GROSVENOR GARDEN'S HOUSE

TOWN PLANNING CONDITION 5(IV) & LISTED BUILDING CONSENT CONDITION 4(IV)
EXTERNAL METALWORK

GGH-AUK-ZZ-ZZ-RP-A-07003 / C03 / 17.01.2024

Drawing Number  
**GGH-AUK-ZZ-ZZ-DR-A-07321** Revision  
**C02**  
 AUK Project Number  
**22127**

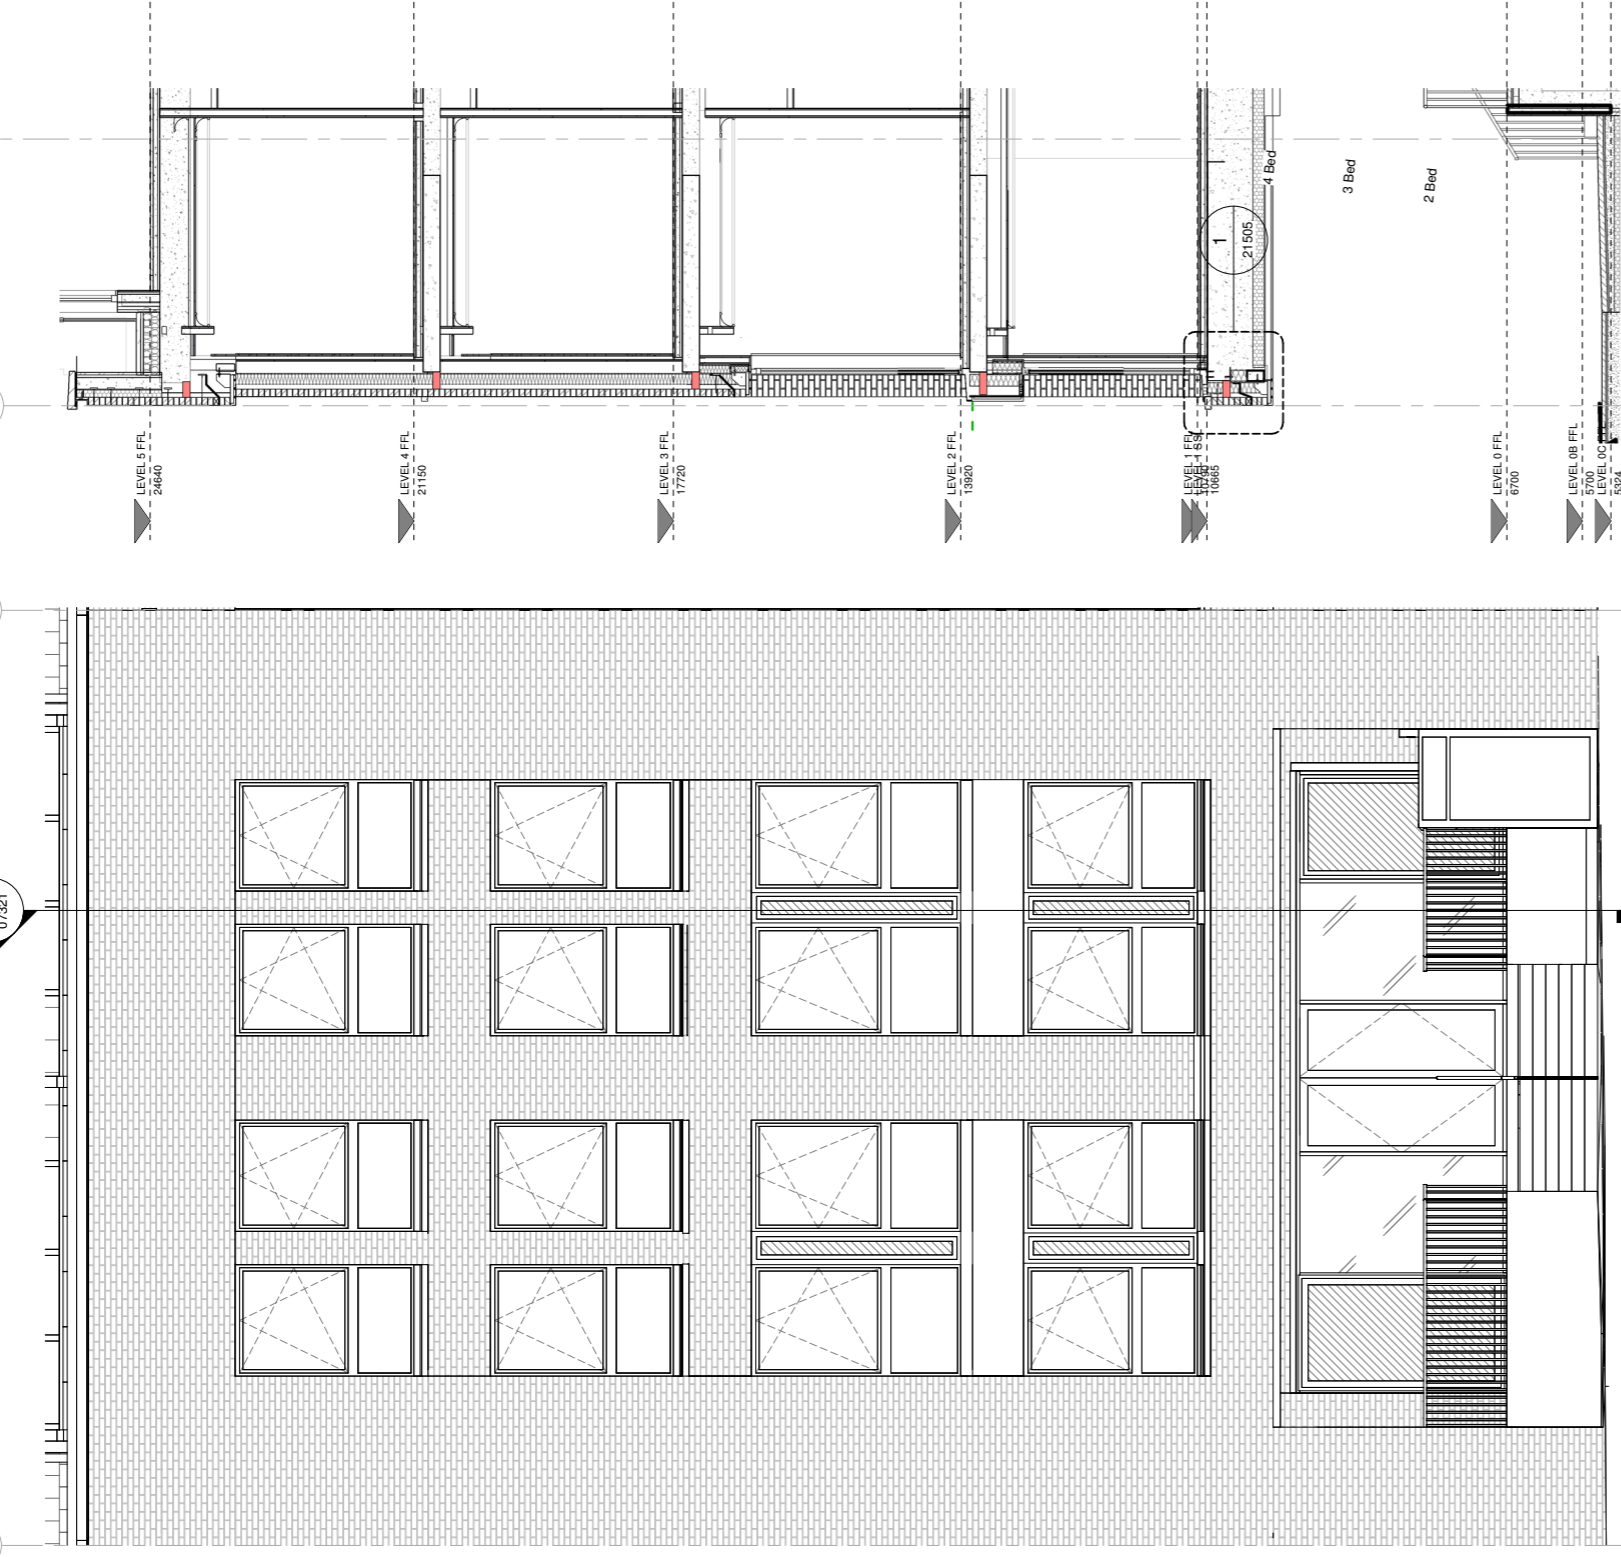
The construction of the new Eaton Lane façade has changed from pre-cast concrete panels with an SFS backing to handset brickwork with and SFS backing. The changes related to this can be seen on the following drawings:

The sills at the base of the inset brick panels on the Eaton Lane façade have been amended. Previously stone sills were shown under the windows but no sill indicated at the point where the brickwork steps out. The stone sills below the windows remain as before and a metal flashing has been introduced to the step in the brickwork. This change can be seen on the following drawings:

- GGH-AUK-ZZ-ZZ-DR-A-07320
- GGH-AUK-ZZ-ZZ-DR-A-07321
